**Inland Rail - Narromine to Narrabri (SSI 9487)  
EIS**

Liz Rogers  
Manager, Assessments  
**Water – Knowledge Office**  
5 February 2021

### Detailed advice to DPIE - Planning & Assessment regarding the Inland Rail - Narromine to Narrabri (SSI 9487) EIS

Figure B2.1 **Proposed bore field locations**
(map 1)

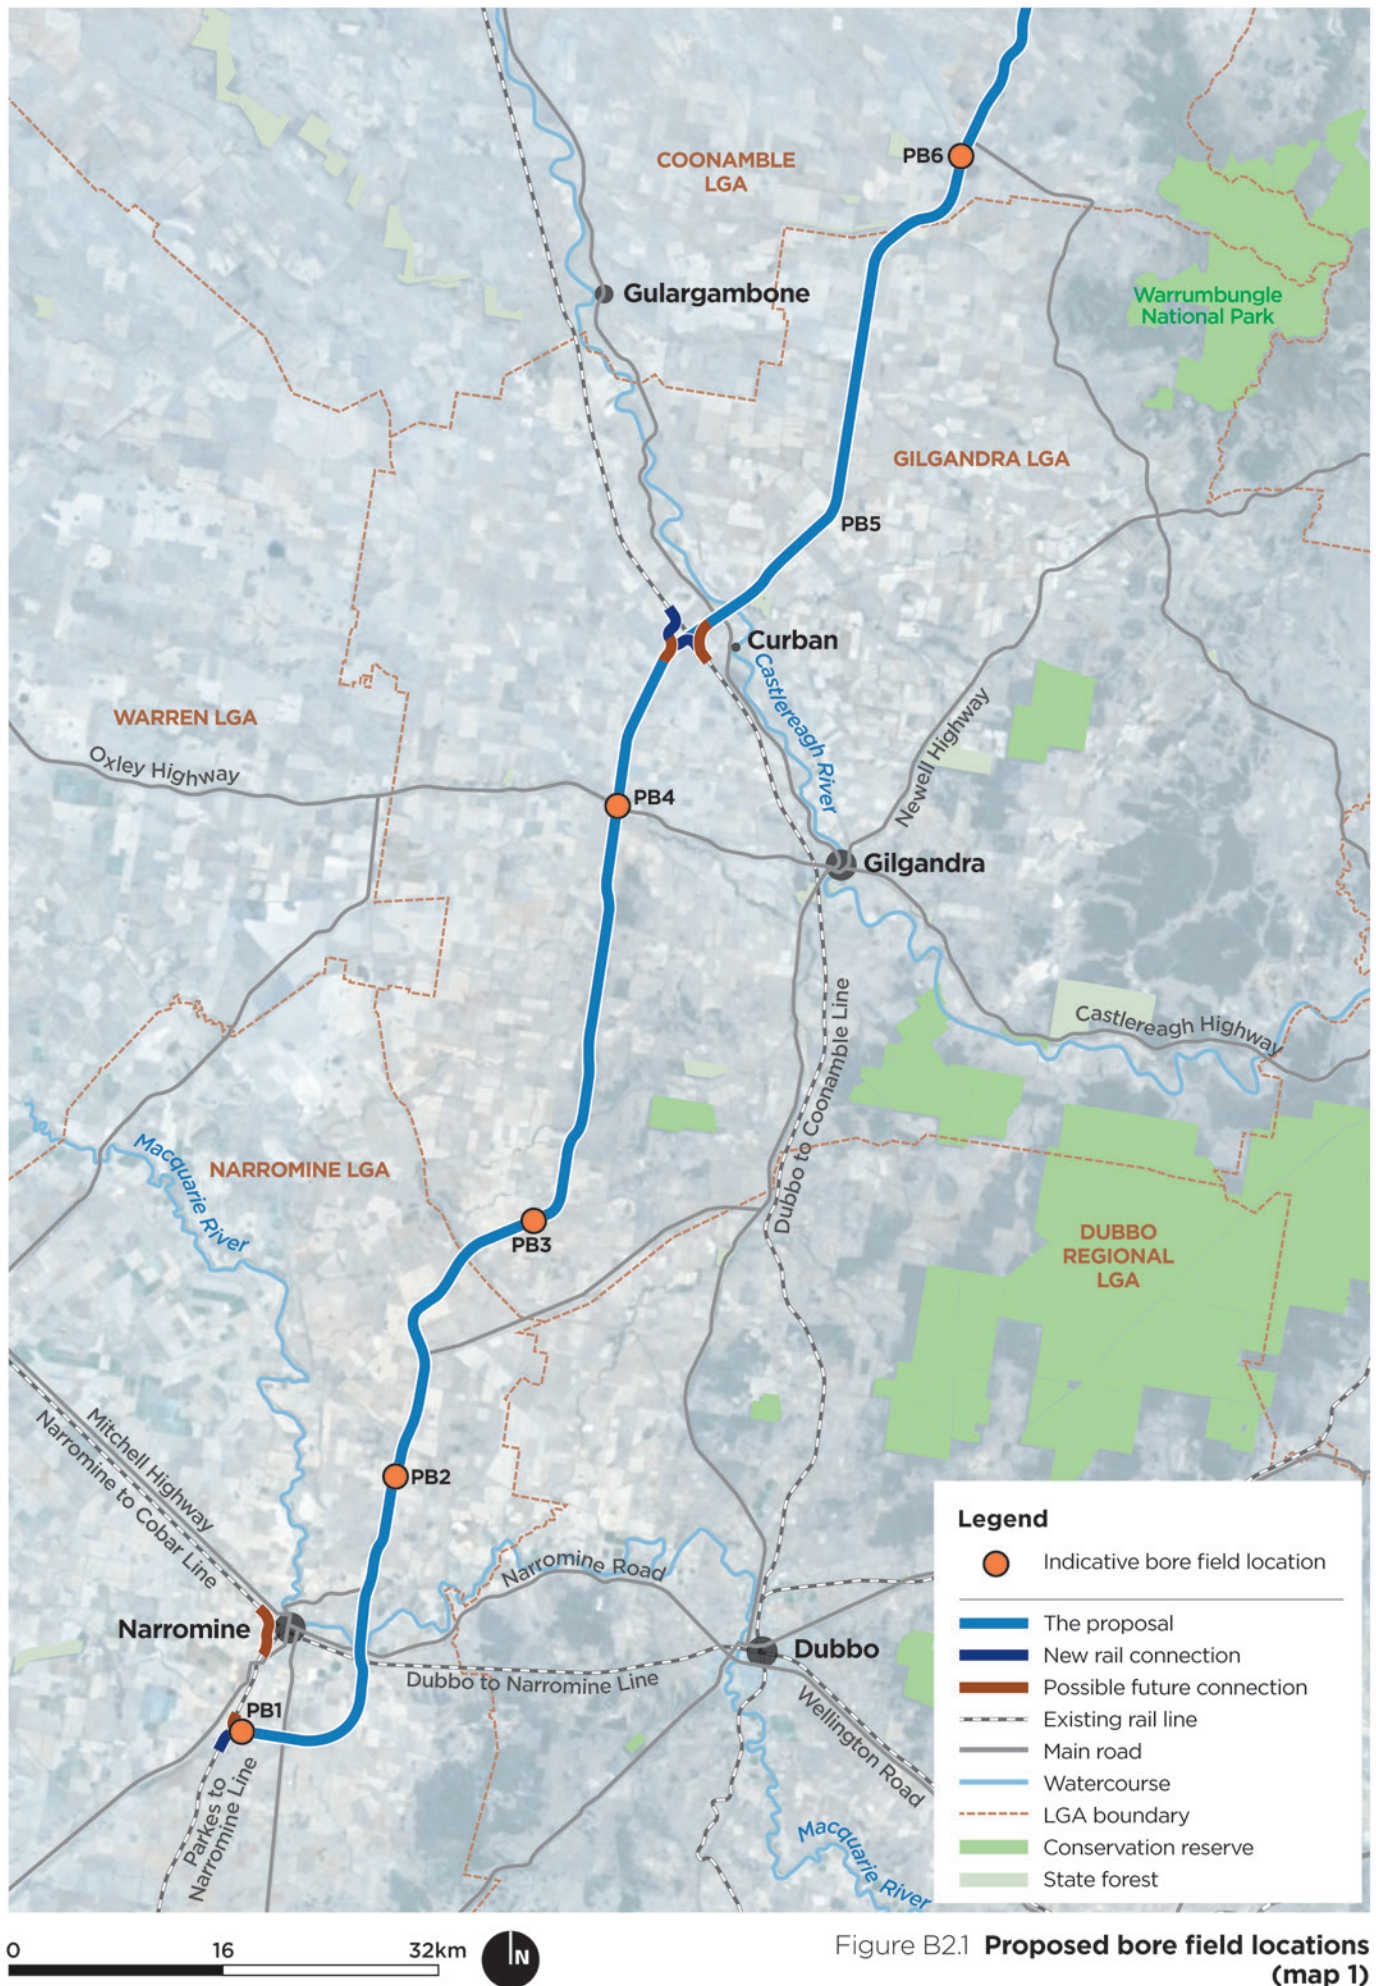
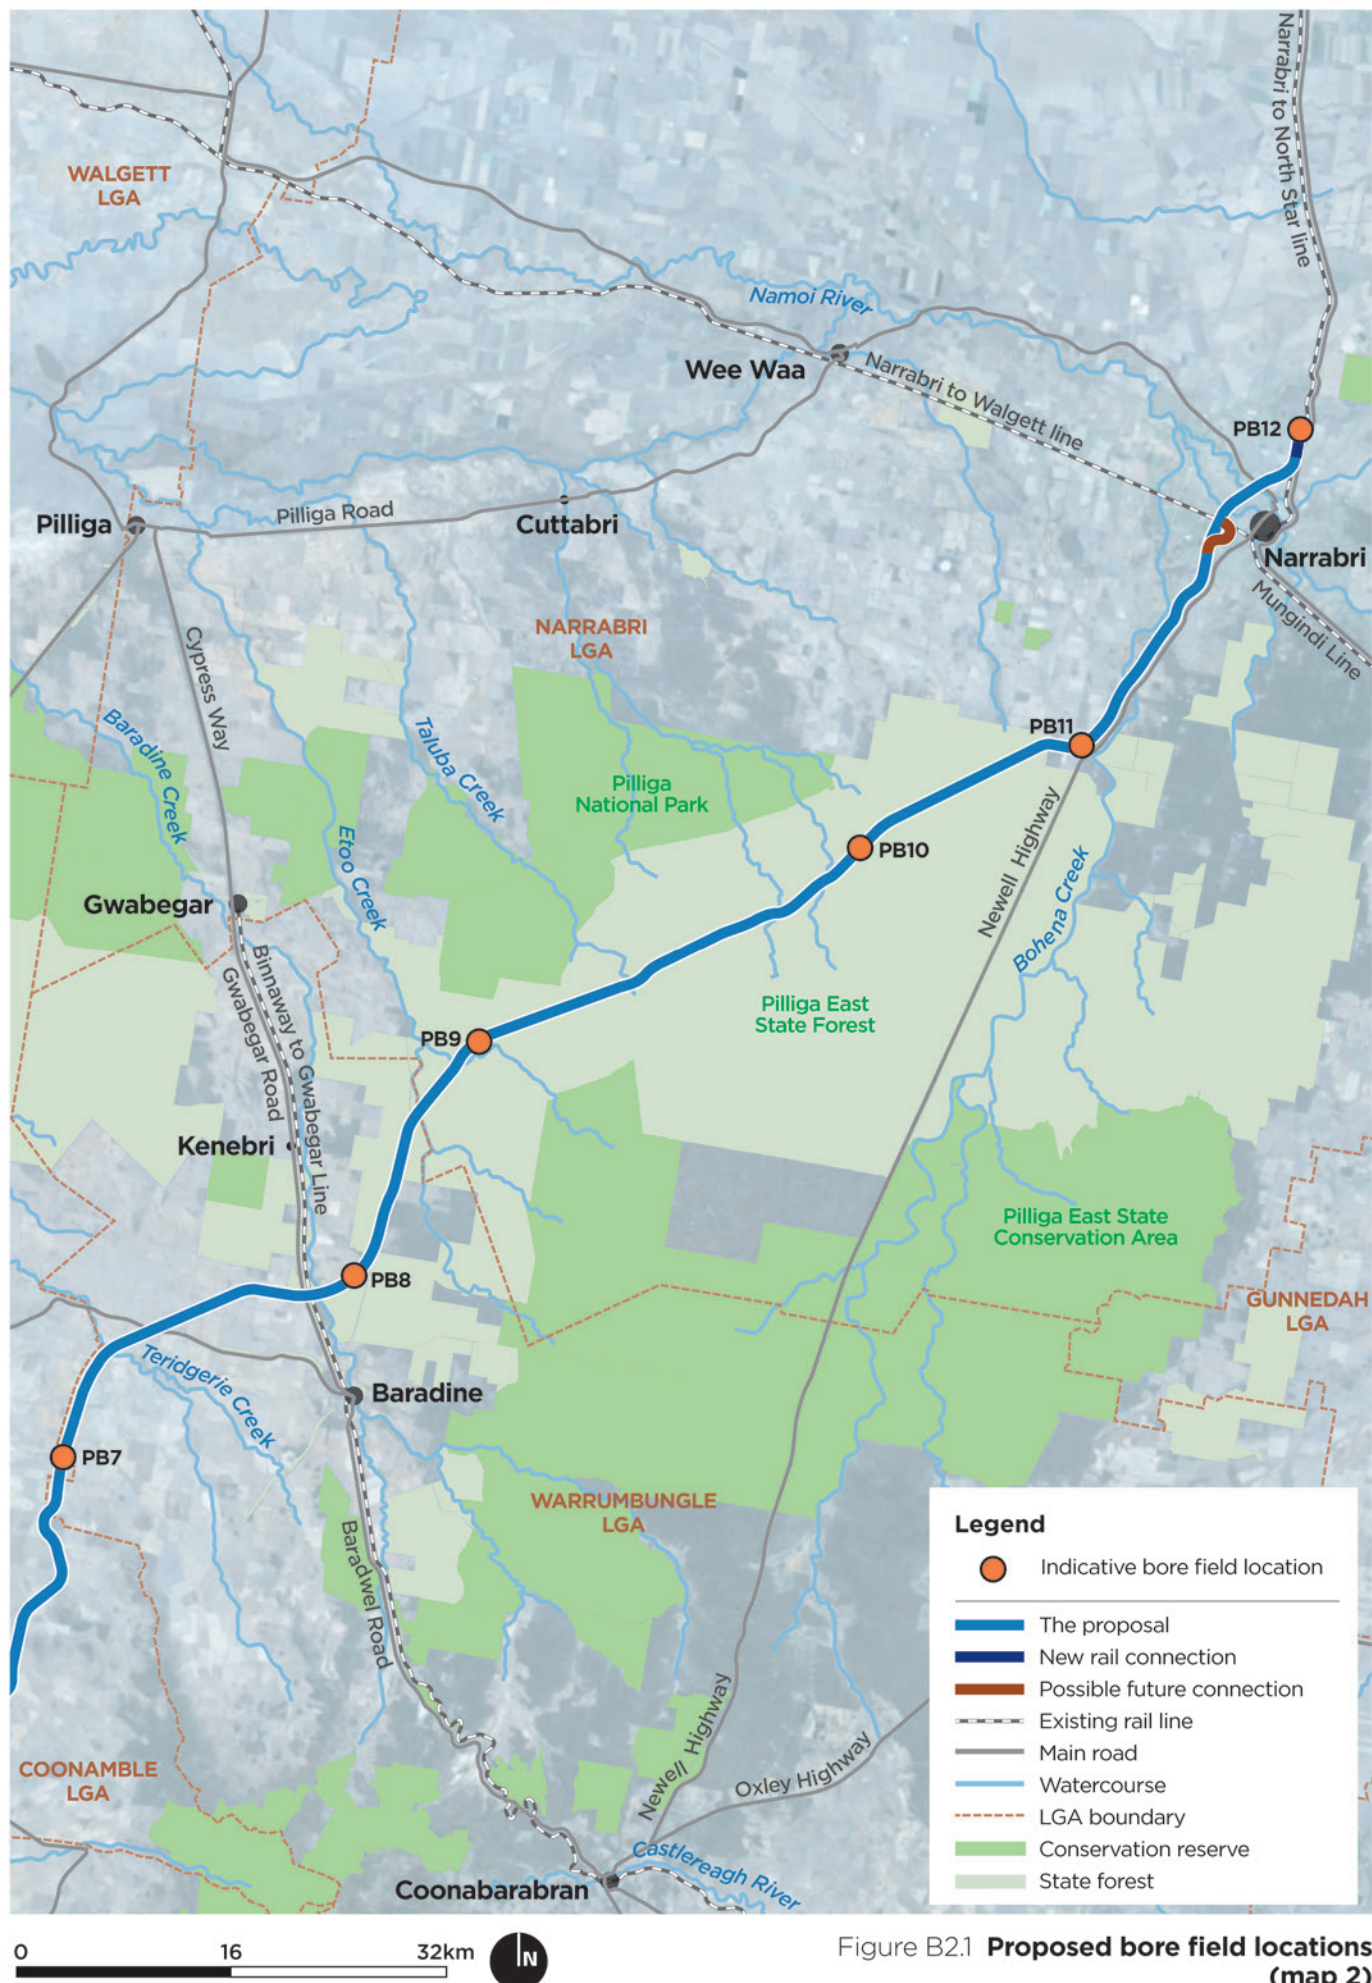
Insufficient information has been provided to ensure a secure water supply is available and this represents a commercial risk for the project. A number of bore fields are proposed along the rail alignment. However, no confirmation has been provided of an agreement with relevant landholders, if sufficient volumes are available or if sufficient entitlement exists where required. Security of supply also needs to be addressed due to the potential for drought conditions. Where new extraction points are proposed or where the proposed volume to be extracted is greater than currently approved, new approvals and/or impact assessments may be required. It is recommended this be confirmed and additional assessments carried out for new works and extractions as part of the SSI assessment to enable exclusion of approval requirements under the *Water Management Act 2000* where applicable.

The feasibility to extract the maximum estimated construction-water and potable groundwater requirements has not been demonstrated. The volumes needed for the proposal may thus be inaccessible and no alternative source of construction water has been identified.

Indicative areas for borelines have been identified with these locations to be refined at a later detailed design stage subject to test drilling results. Potential groundwater impacts were simulated for five of the 12 representative bore fields via individual analytical element, multi-layer transient groundwater models constructed using the software AnAqSim following consultation with DPIE Water in early 2020.

However, justification or further consideration is required regarding the structure of model PB1 and uniform hydrological parameter values applied in model PB2. A drawdown of 4 m, exceeding the aquifer interference policy's minimal impact criterion, was forecast for a neighbouring bore by groundwater model PB1 but waived by assuming extraction is mainly from geologic material represented by model layer 1. Conversely, that bore had been drilled beyond the model layer 1 boundary depth of 66 m through what the driller had described as a water supply zone to 73 m in depth and clay gravel to 76 m in depth. Thus, 10 m of productive basal alluvium is represented by model layer 2. The groundwater model PB2 was assigned identical hydrological parameter values for all three layers without providing justification (Tech Report 4, Table 4.6). These uniform model properties have resulted in a forecast drawdown at a neighbouring bore exceeding the aquifer interference policy's minimal impact criterion.

- Clarification be provided of the ability to obtain a secure water supply for the project. This is to include relevant agreements where required and to demonstrate sufficient water entitlements can be acquired where necessary. Where the water is to be sourced from a currently unauthorised source and/or where additional water take infrastructure is required eg. borefields, an impact assessment of this infrastructure development and water take will be required. The impact assessment and access to additional water entitlement will be required to meet the rules of the relevant Water Sharing Plan, the Access Licence Dealings Principles Order (2004) and DPIE Water's Factsheet – Assessing Groundwater Applications

- The Bore Field Extraction Plan(s) must be submitted to DPIE Water/NRAR for consultation and endorsement. The Plan(s) must be submitted a minimum three months prior to bore construction. All bore (exempt or not) cannot be constructed or pumping commence until DPIE Water have endorsed this plan.

- The Bore Field Extraction Plan(s) must include at a minimum:
- Detailed information on bore location, water source, depth and proposed volumes of take per year per bore.

Figure C3.1 Indicative layout - borrow pit A (Tantitha Road, Narromine)

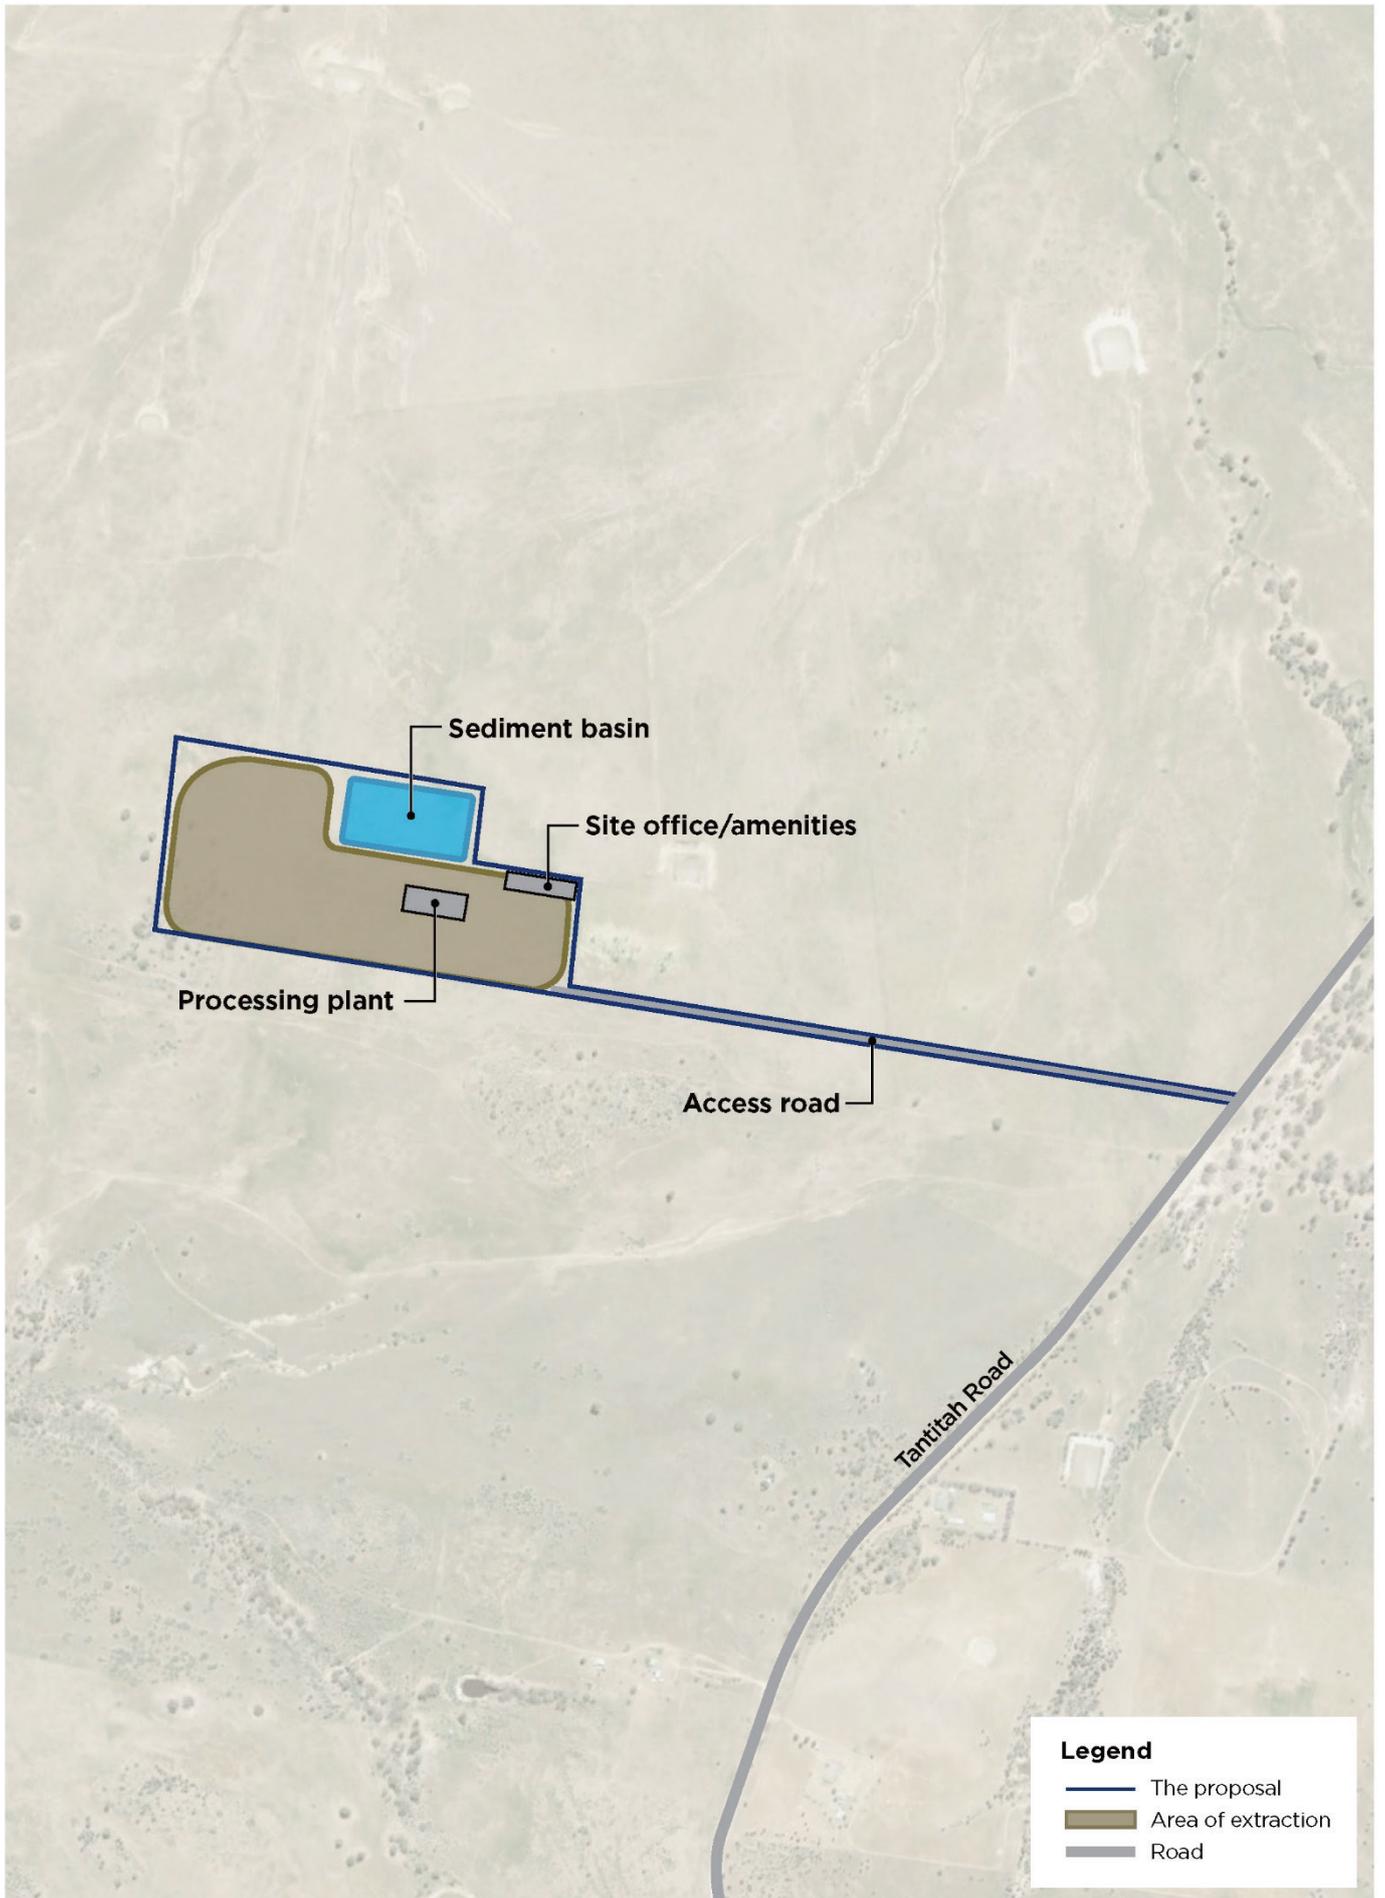
The proponent has concluded that only one proposed excavation, borrow pit A, would likely intersect the groundwater table and result in an estimated maximum groundwater inflow of 0.3 ML/year. As the groundwater take that may occur at Borrow Pit A is expected to be less than 1 ML per year. Where there is the potential for total water take associated with an aquifer interference activity to exceed 3ML, sufficient entitlement must be obtained in the relevant water source prior to any extraction or interception. The impact calculations as presented for borrow pit A, however, are incorrect, are not traceable or repeatable, and were validated with an unrepresented sensitivity analysis.

It is noted that borrow pit A will not impact any third-party bore or high priority groundwater dependent ecosystem. The depth of bore BH-2-093, representing the aquifer at borrow pit A, is inconsistently presented as either 9.55 m below ground (Tech Report 4, Table 7.1) or with a maximum screen depth below ground being 10.1 m (Tables 4.2, 4.4, 5.10, 5.11). The surface elevations of all borrow pits are also inconsistent between Tables 4.2 and 7.1.

Impacts from the take of water associated with an aquifer interference activity, i.e. the indirect or consequential take of water from the interception of an aquifer are to be assessed against the 'minimal impact considerations' of the NSW Aquifer Interference Policy (2012). This applies to 'borrow pit A'. The proponent has not directly provided an assessment of the requirements against the Aquifer Interference Policy.

- For the take of water within borrow pit A where take is presented to be less than 3 ML/yr, an exemption is available under cl. 7 of Schedule 4 of the *Water Management (General) Regulation*. To exercise this exemption certain requirements must be met to ensure that less than 3 ML of water is taken. To qualify for the exemption, refer to clause 21(6) of the *Water Management (General) Regulation 2018* which includes requirements to:

- For the supply of groundwater for consumptive purposes to an aquifer interference activity, the water supply works must be assessed as per a water supply dealing and not under the NSW Aquifer Interference Policy.
- The proponent should provide an assessment of the take of water from borrow pit A against the requirements of the NSW Aquifer Interference Policy.
